Recommendation Report for Planning Permission for Works or Extension to a Dwelling

REF NO: M/36/26/HH

LOCATION: 68 Ancton Way
Elmer
Middleton-on-sea
PO22 6JP

PROPOSAL: Ground floor alterations and new first floor extension.

PROPOSED ELEVATIONS

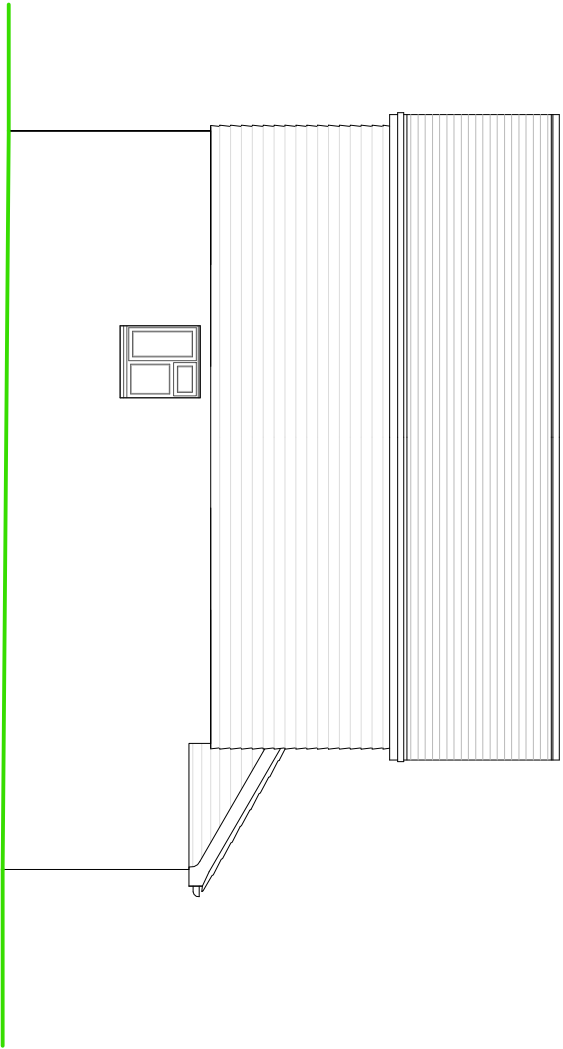
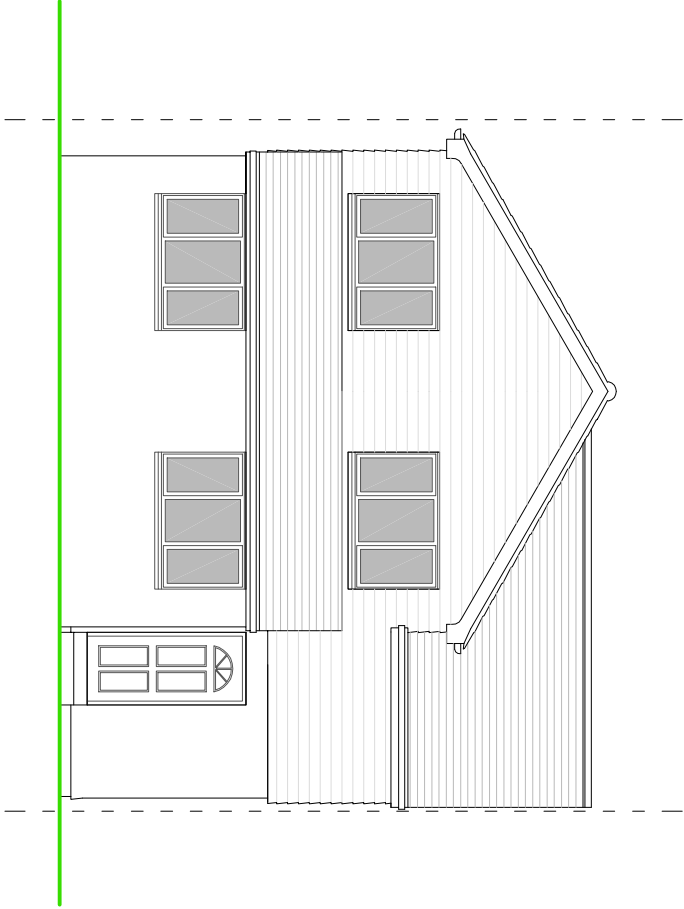
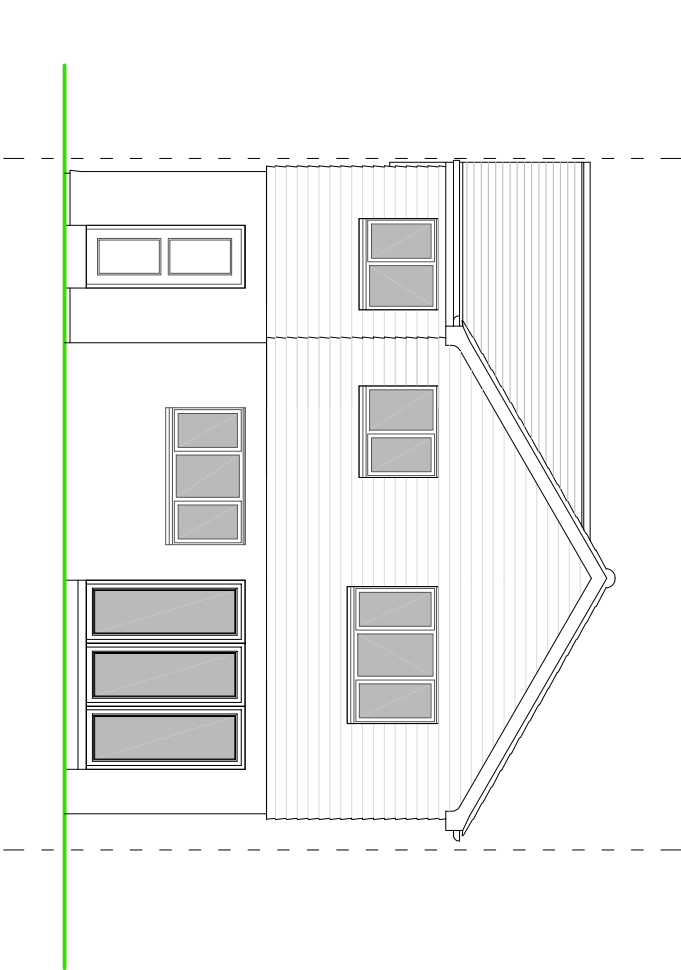
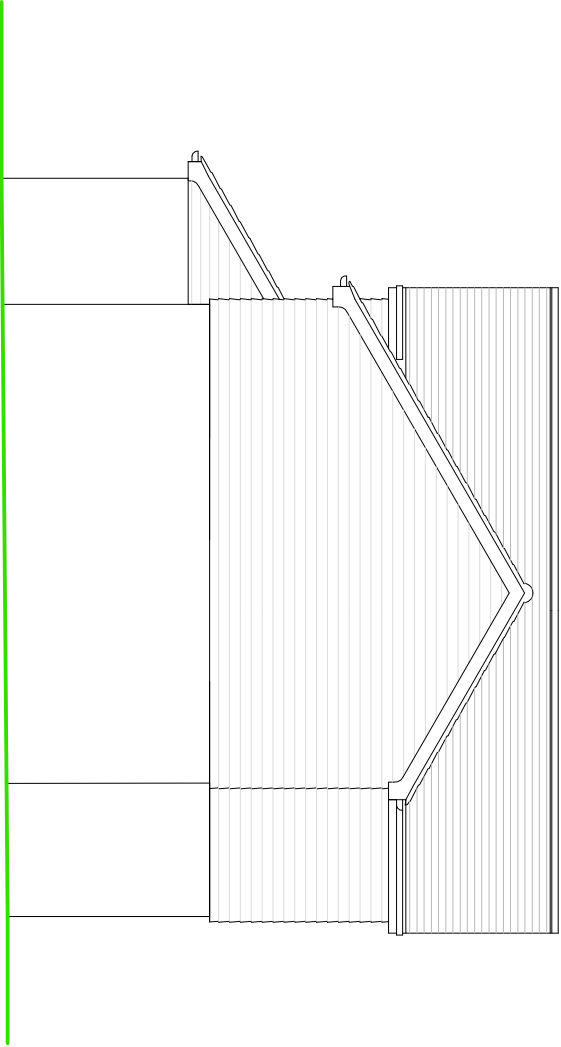
The proposed first-floor extension would introduce new first-floor accommodation. It would have a maximum width in line with the ground floor, at 8.5m wide, and a maximum depth of 8.1m. It would maintain the gable-end feature to the front and rear, reflecting the character of the host dwelling, with a maximum height of 7.3m, increased from 4.6m, matching the height of the west-side neighbour, No. 66. To the east side, the ridge would be set down by 0.3m. It is noted that there are several examples of alterations and extensions within the street scene, including the construction of a new two-storey dwelling at No. 66 Ancton Way and No. 72 Ancton Way. As such, the increase in scale and massing would not appear out of keeping within the street scene or the wider locality.

Given the nature of the proposed extension, it would not be a subservient addition to the existing dwelling. However, the proposed extension would reflect the character of the host dwelling, with a pitched roof form to match the existing. Moreover, the dwelling is set 5.7m back from the boundary with the highway and would not appear unduly prominent within the street scene. The extension would be finished with roof materials and fenestration to match the existing, with light-coloured cladding to the first floor and render to the ground floor. There is white cladding on the existing building, so its introduction at first-floor level would not be out of keeping within the locality.

The additional fenestration within the front elevation would have an outlook over the application site frontage and would not result in any overlooking. No first-floor side windows are proposed. To the rear, additional fenestration would provide an outlook over the rear garden and onto fields beyond the rear boundary. Whilst some views of neighbouring gardens would be available from the first floor rear fenestration, these views would not be so significant so as to justify the refuse of planning permission in this regard.

PROPOSED GROUND FLOOR PLAN

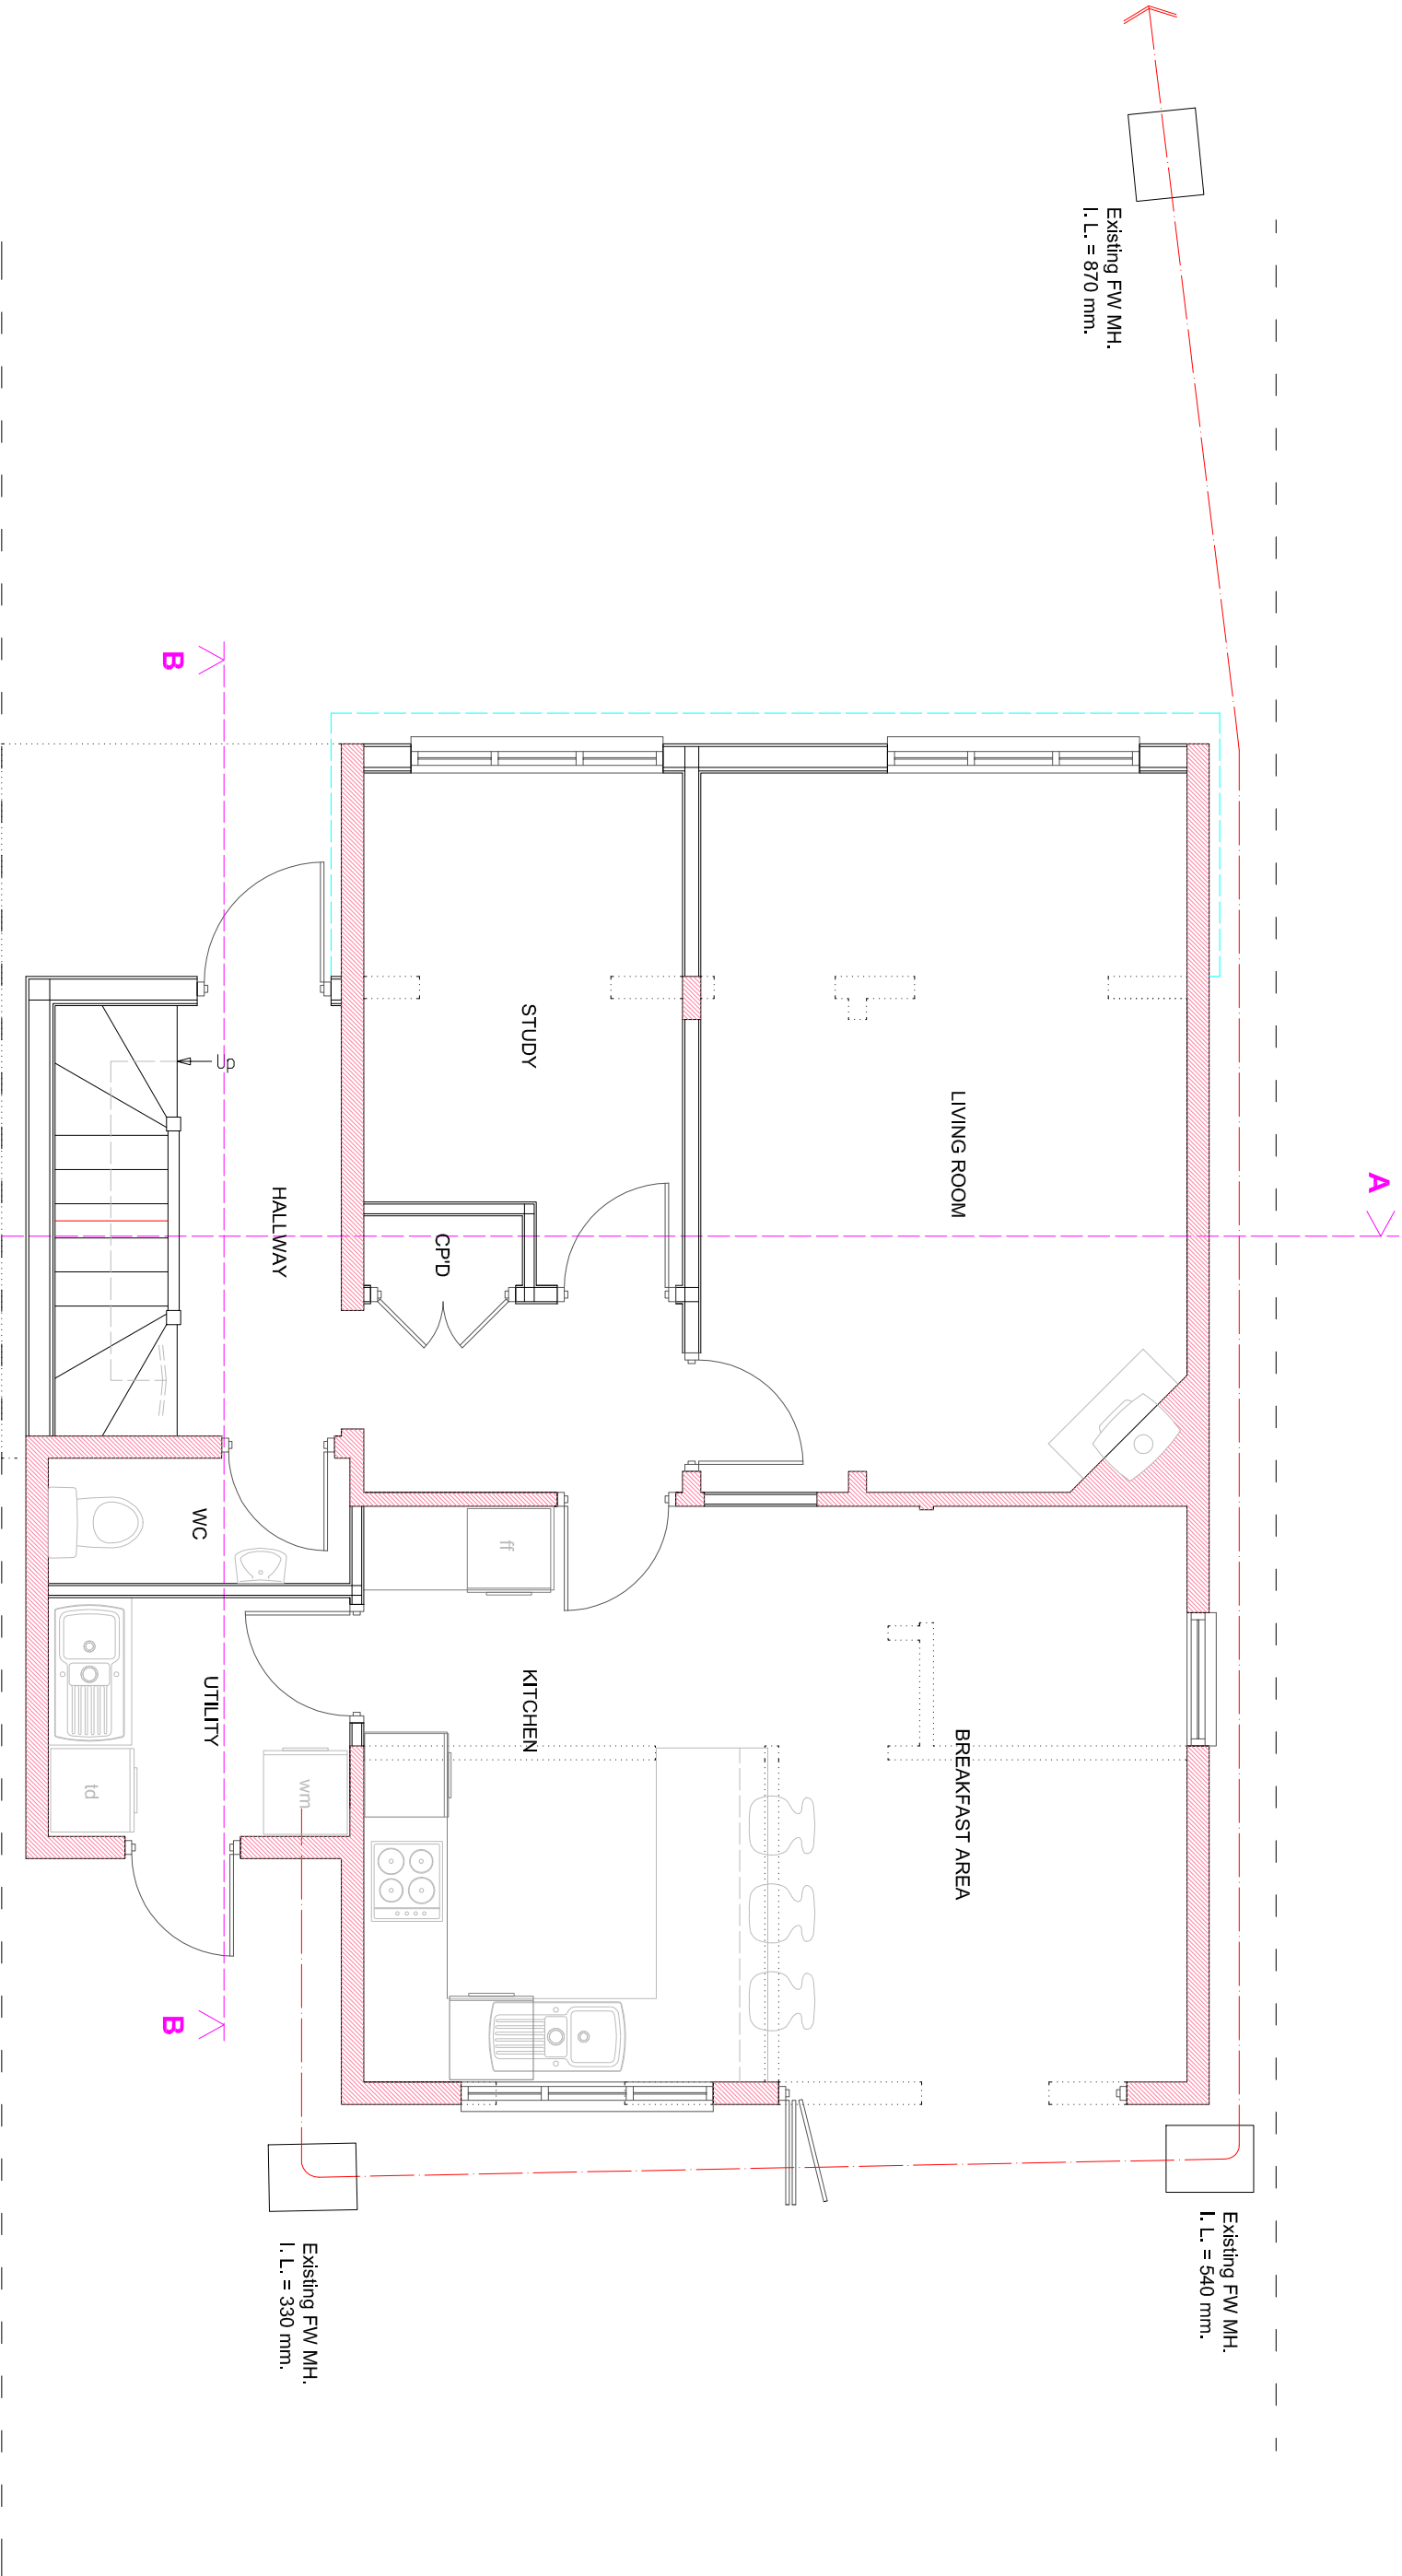
Proposed alterations to the ground floor include remodelling the front elevation, including relocation of the front entrance following the partial demolition of the existing garage. Overall, there would be no increase to the existing footprint; rather, there would be a 1.6m reduction in the depth of the east-side element. To the rear, bi-folding doors are proposed. The alterations are acceptable and would not result in harm to the character or visual amenity of the host dwelling.

The proposal involves the loss of the current garage, resulting in the loss of one parking space. However, the existing garage does not meet the internal space standards of 6m by 3m set out in the Arun Parking SPD; therefore, its loss would not result in the loss of a parking space. The resultant parking provision would provide at least one space, with further parking provision available within the application site frontage, and therefore the proposal would not result in any overall loss of on-site parking provision. As such, the loss of the garage is acceptable.

PROPOSED STREETSCENE
ELEVATION

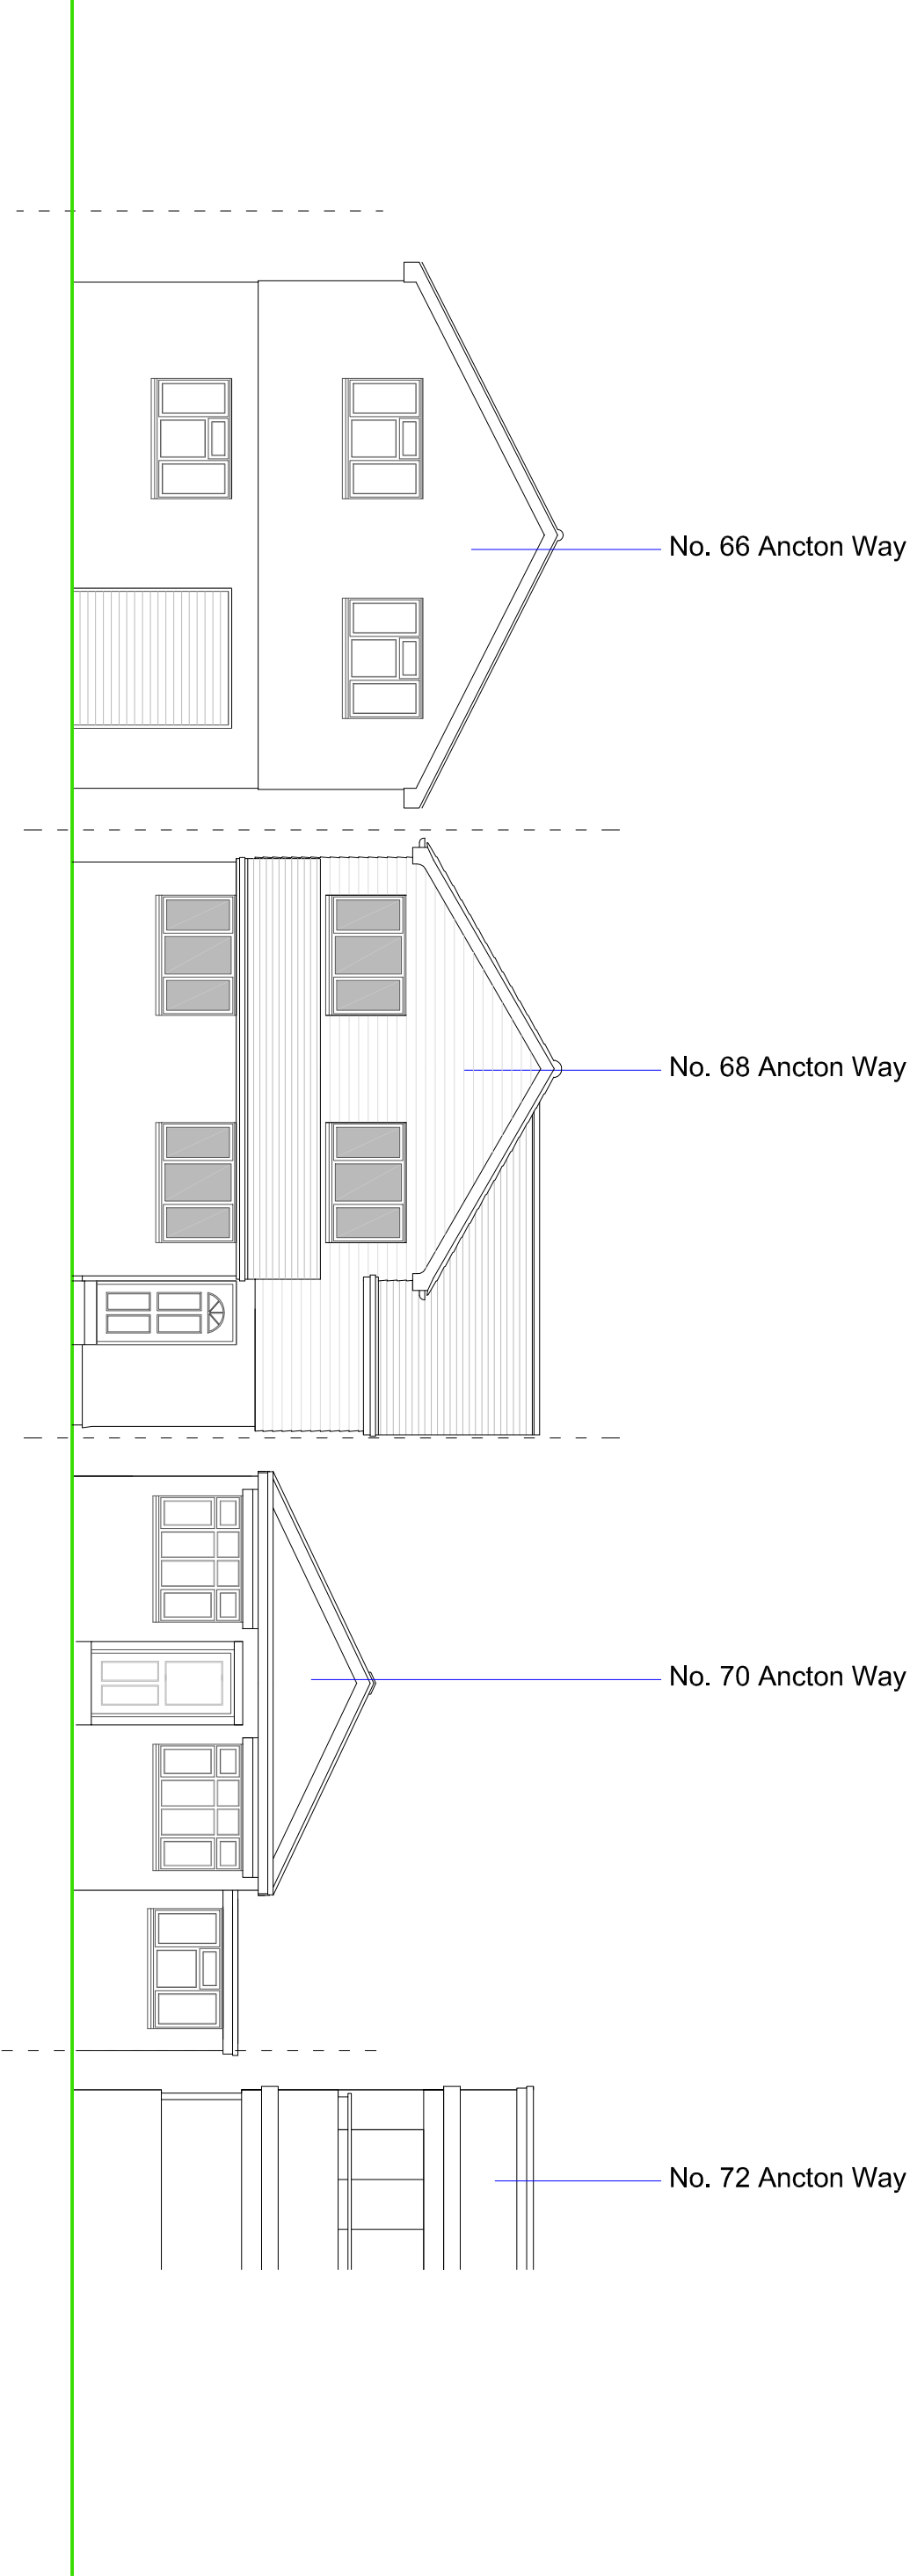
Overall, the proposed development would not result in an increase to the footprint of the host dwelling. The alterations would change the character of the dwelling in terms of its scale and massing. However, given the varied character of the street scene, the proposed works would not result in harm to the character or appearance of the host dwelling, and the alterations and extension would integrate well with the existing building. The proposal is therefore in accordance with Arun Local Plan policies D DM1 and D DM4.
